25 February 2022

BOWMANS CREEK WIND FARM (SSD-10315)

This letter has been prepared to provide further information and respond to recommendations, as requested by DPE, Heritage NSW and BCD.

Photomontage view from F18-1 Dwelling: Approximate distance to turbine T59 is 3,260 metres **Viewpoint location:** E: 131119 N: 6427300 **Turbine dimensions:** 150m hub, 220m tip

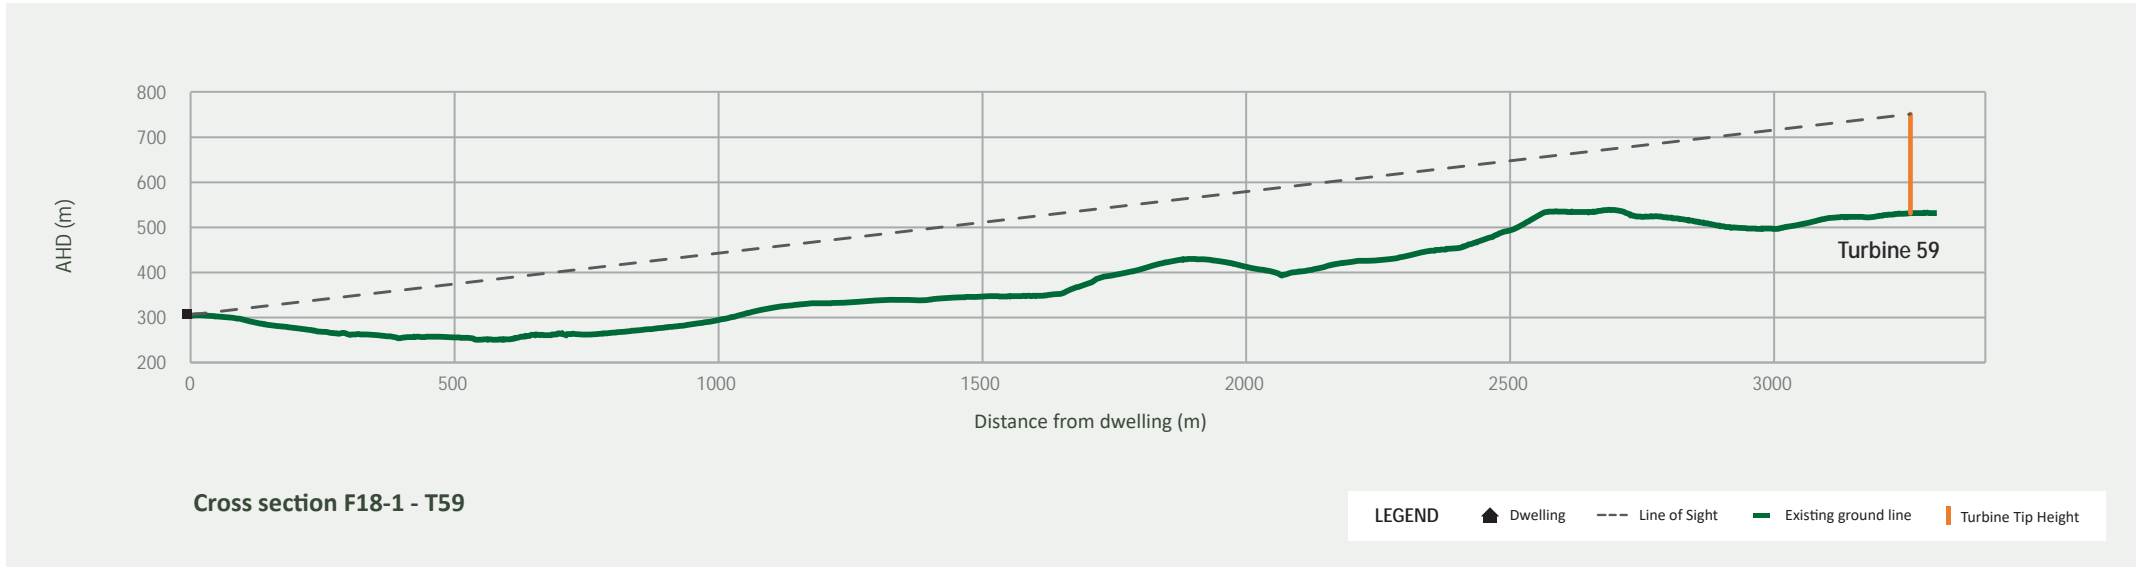
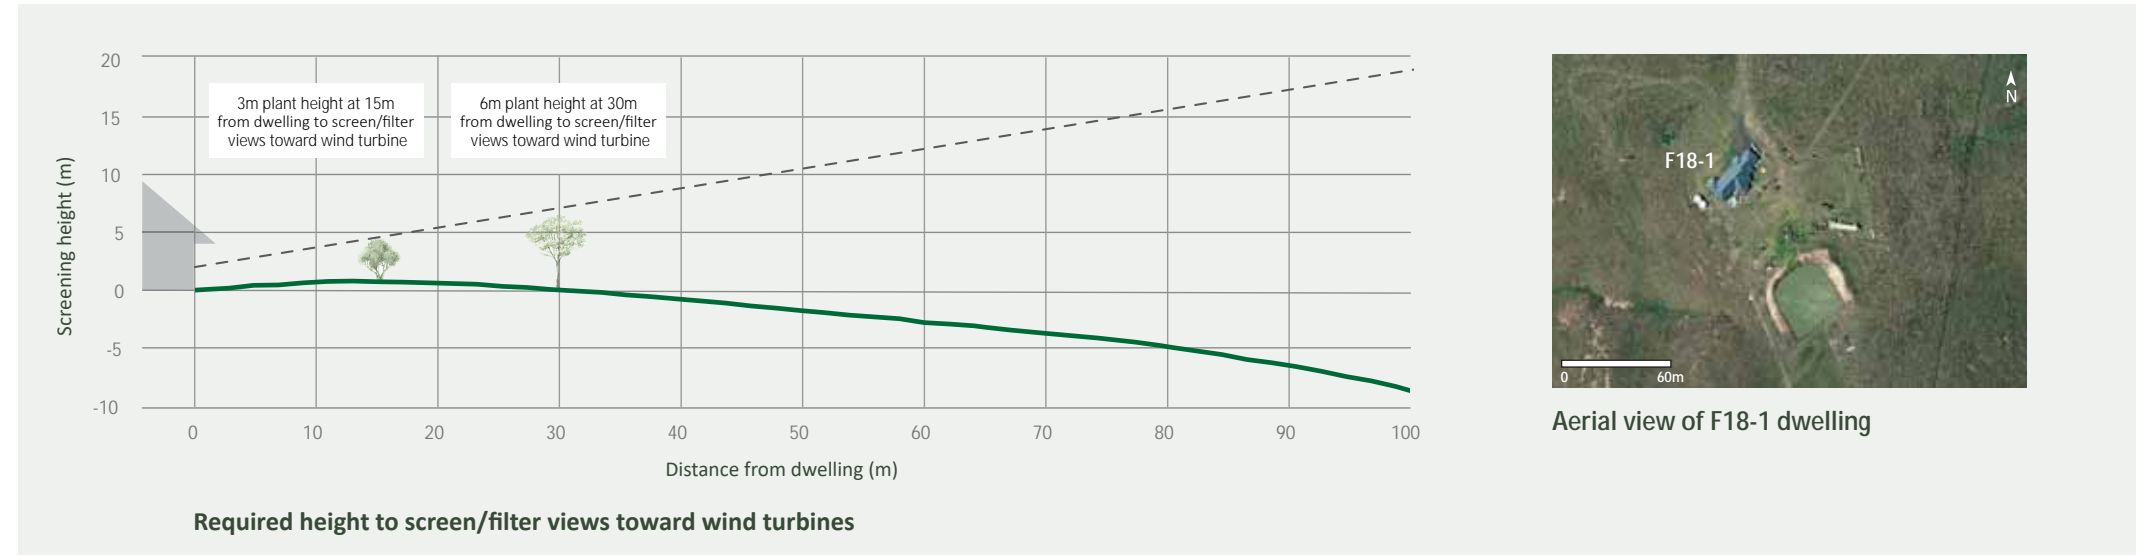
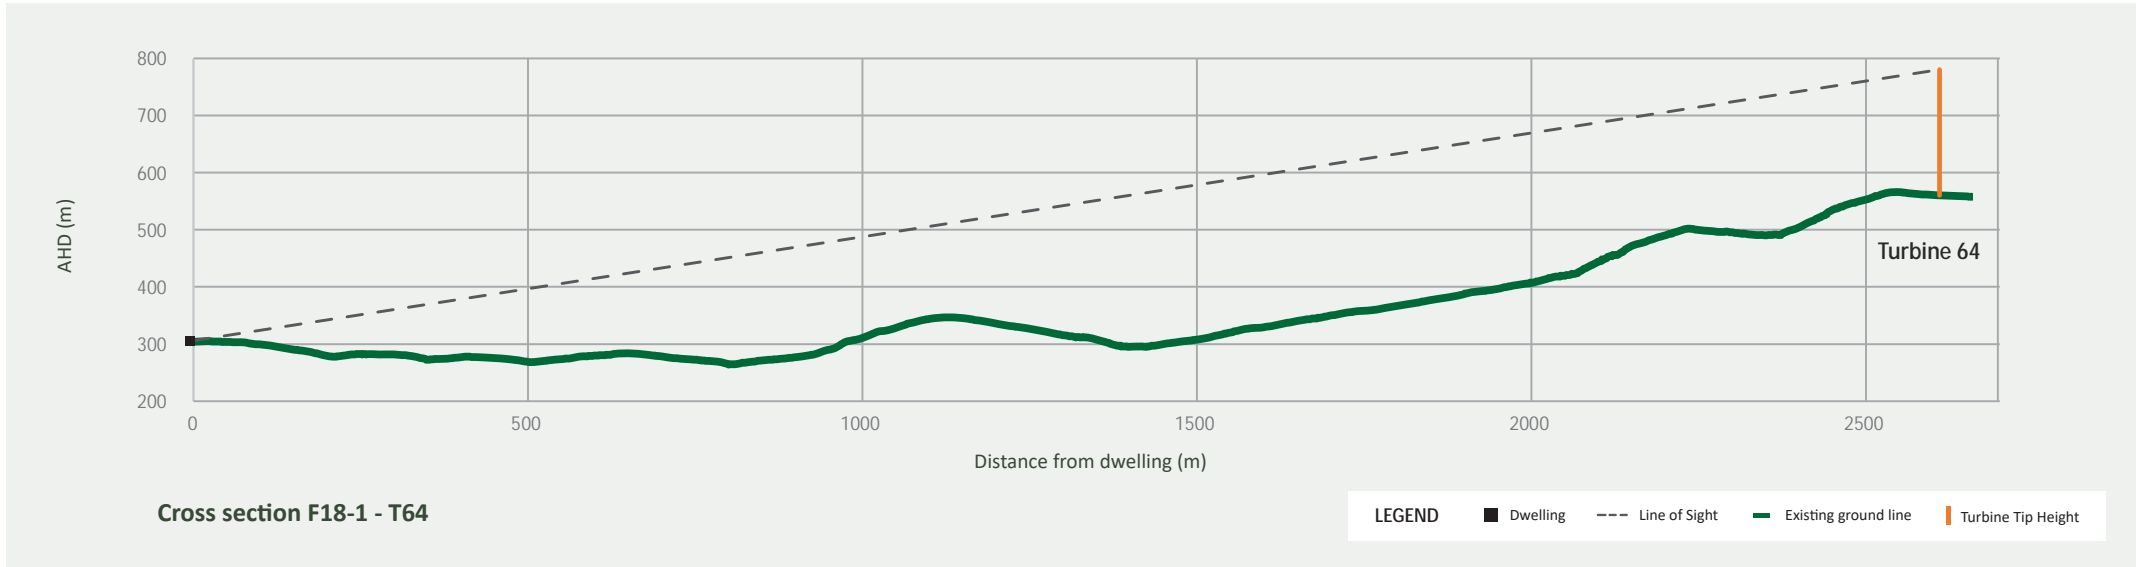
- Provide for the following:
 - Residence F18-1;
 - Residences Q17-1, Q17-2, Q17-3 (representative) capturing all potential views of turbines; and
 - Confirm the residence reference number for Figure 30 of the LVIA (this may be K23-1, not O22-1).

Additional photomontages are provided in **Appendix C**. The residence reference for Figure 30 of the LVIA should have been noted as K23-1 (not O22-1). The amended photomontage for k23-1 is provided in **Appendix C**.
